From: Richard Goodall [REDACTED]
Sent: 30 July 2018 16:33
To: Simon Davis
Subject: Re: P/43/18/DOC Sefter Farm

We have just had a comment from our Landscape officer to say: "The information provided in Constructed Wetland Draft Layout dwg 017 rev 07 details an indicative screen

client	BARFOOTS OF BOTLEY LTD.		
project	Proposed Production Facility Setter Farm		
title	Constructed Wetland Draft Layout		
date	scale @ A1	drawn	chkd
Sep. 2017	as shown	GBC	
project no.	drawing no.	rev	
1603	017	07

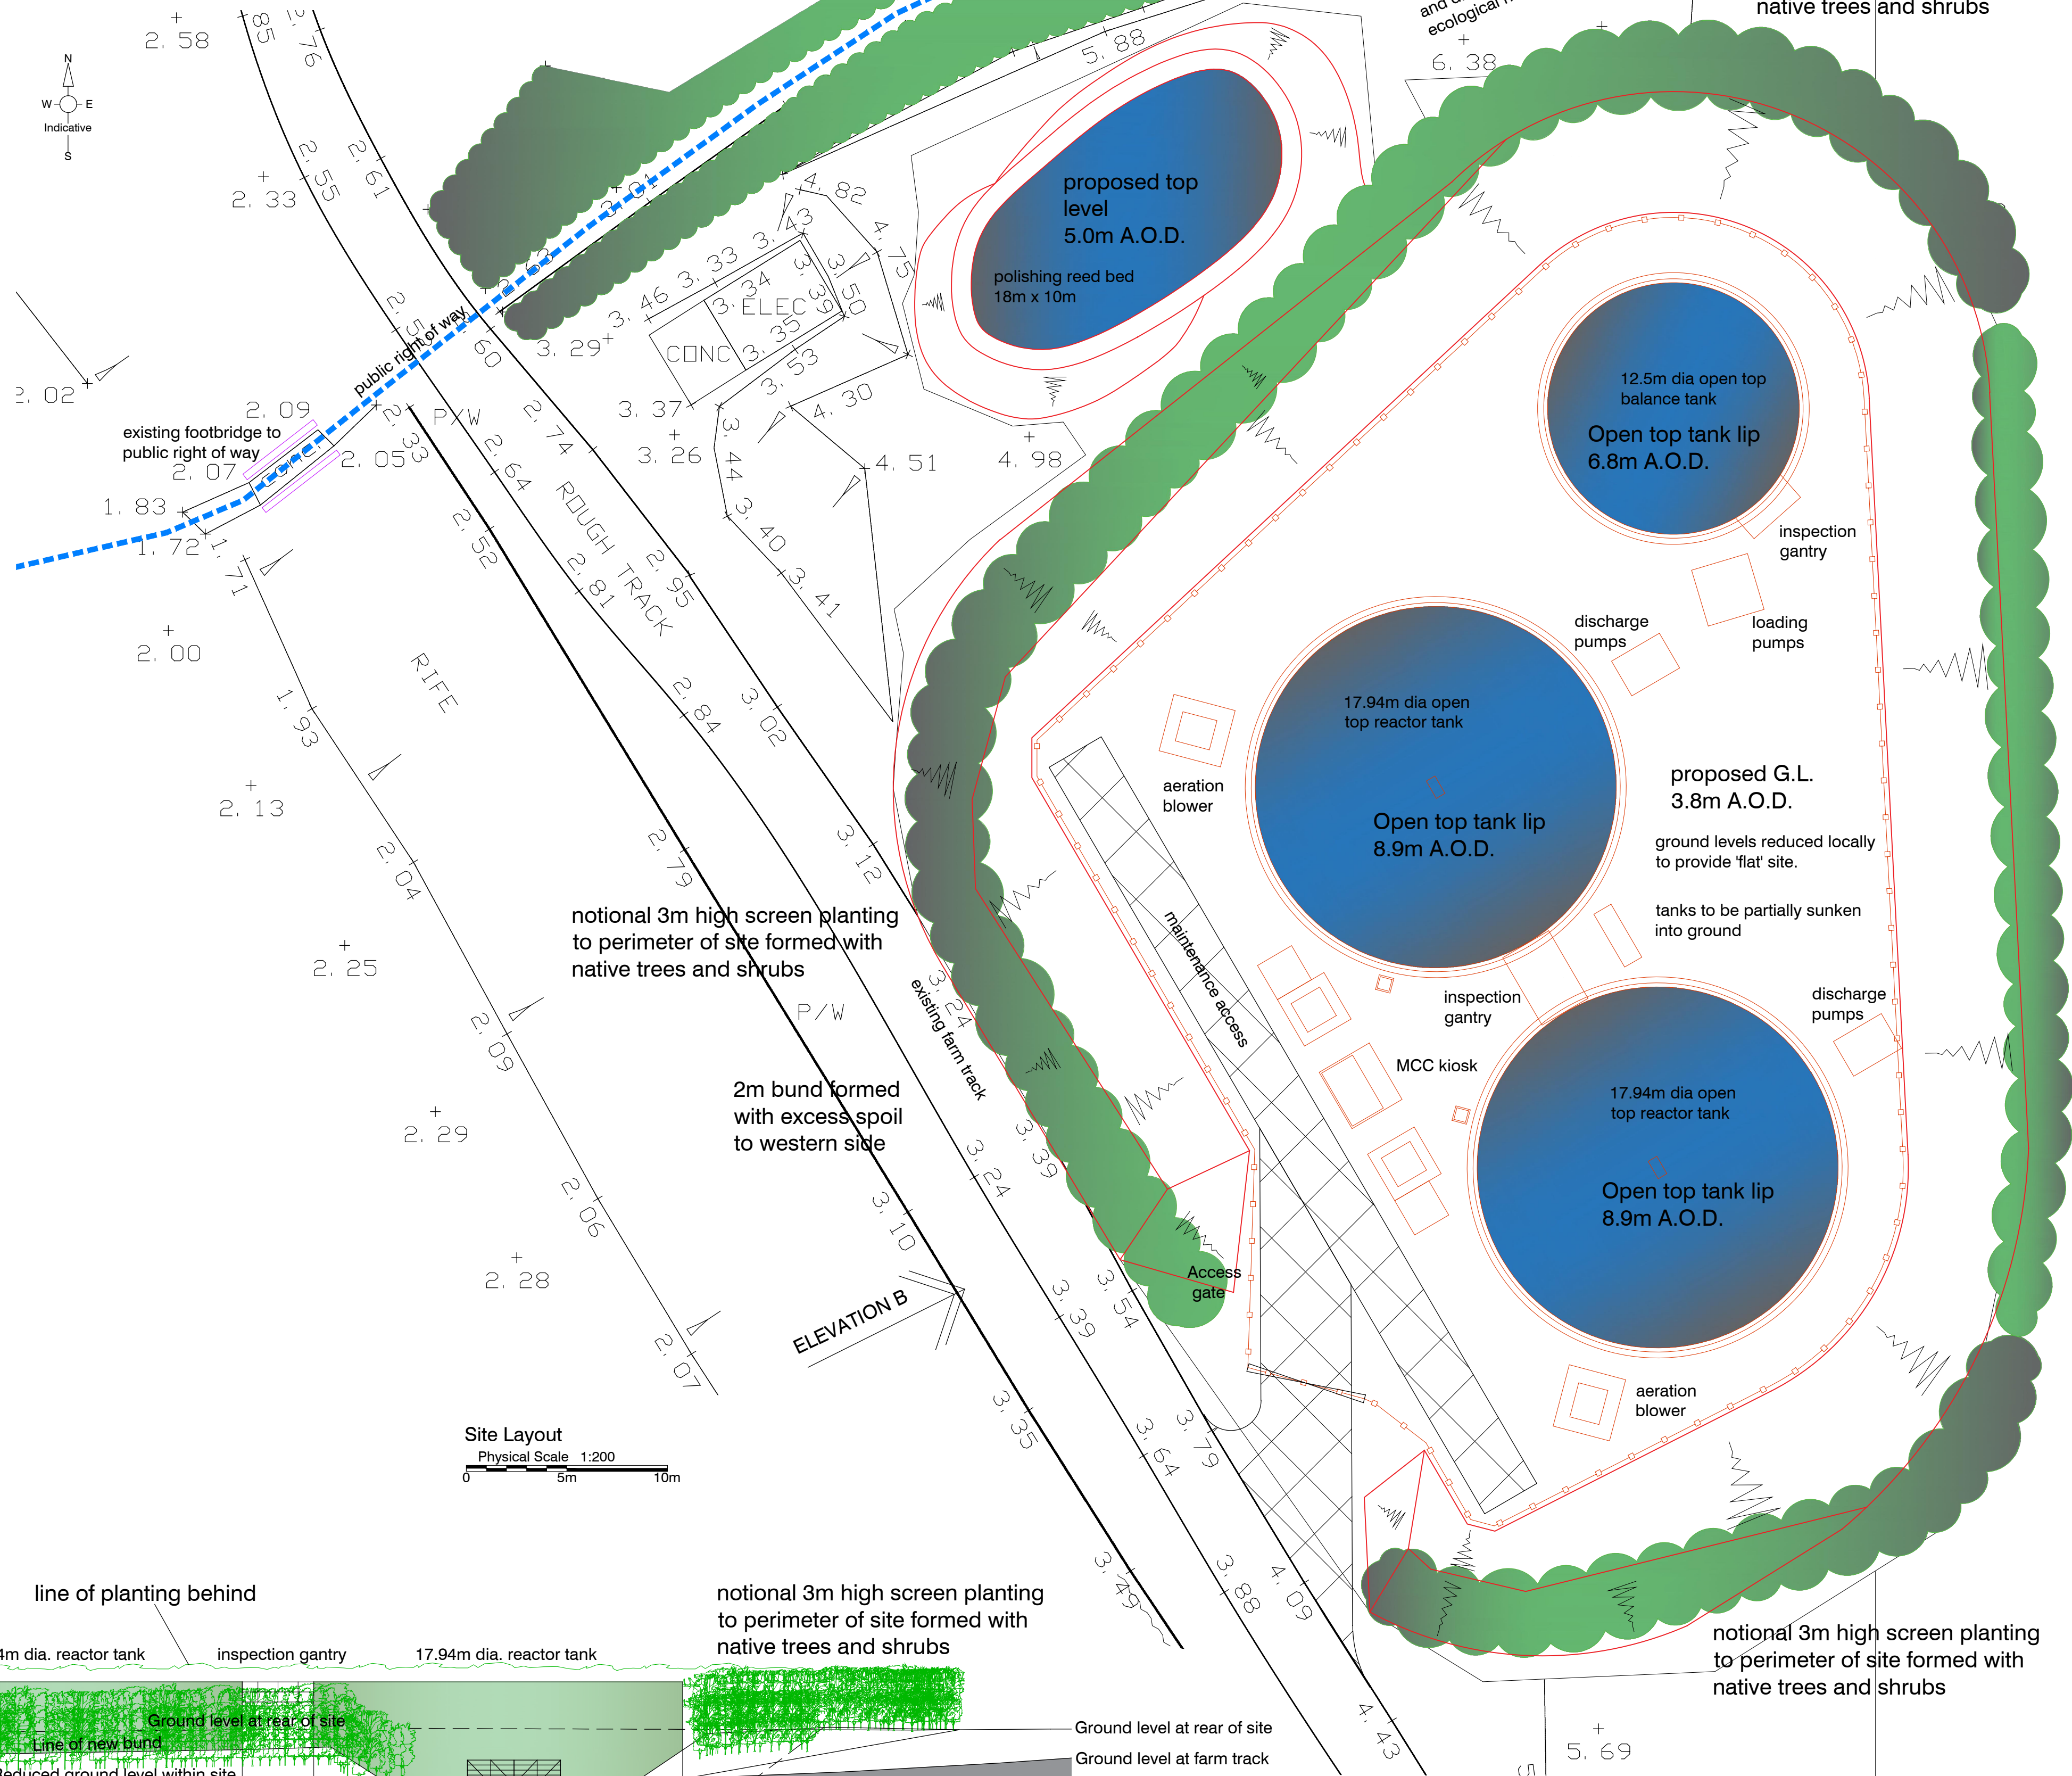
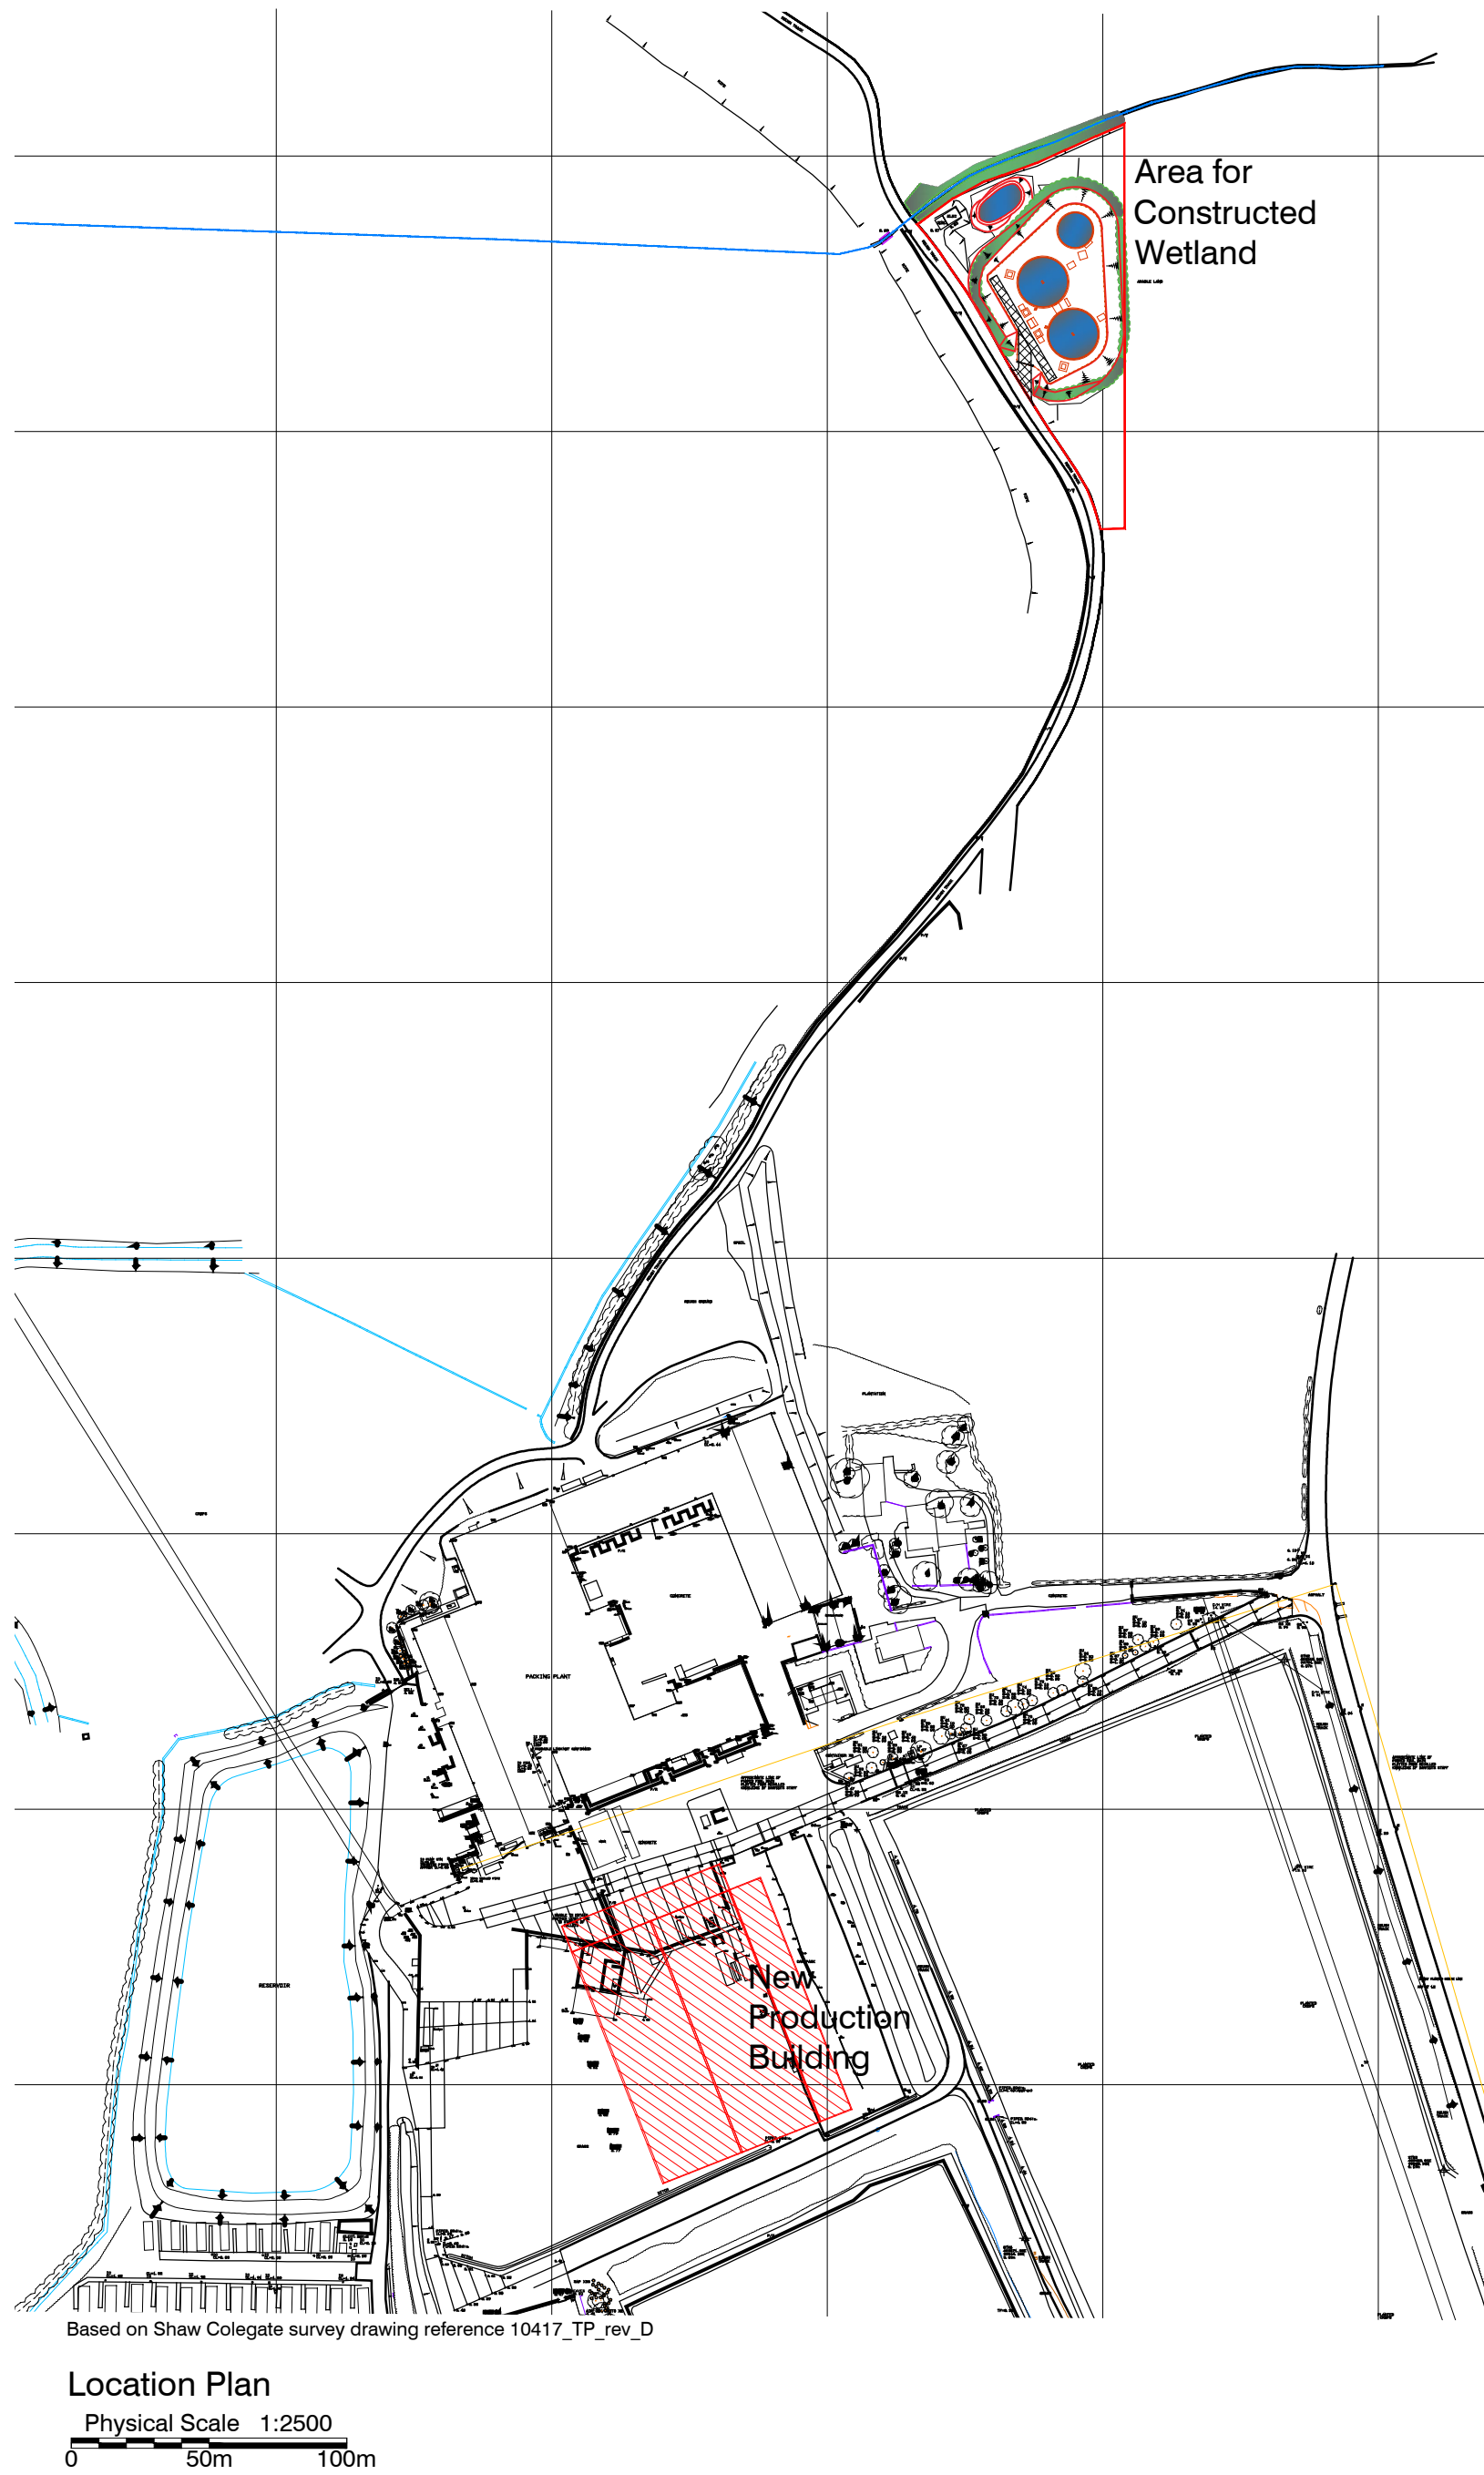
planting to the perimeter which is shown as native planting. Whilst this is suitable or location the detail is not sufficient enough and needs to detail in plan form actual species choice, planting density and size at time of planting. This information needs to be submitted for approval before condition 11 re Landscaping can be considered for discharge. We would therefore not recommend the discharge of Condition 11 landscape scheme until the above information has been submitted for approval.

There are no objections from our ecologist or Nat England but I would request that the drawig be chanmged as per the above before we can determine this. I look forward to hearing from you.
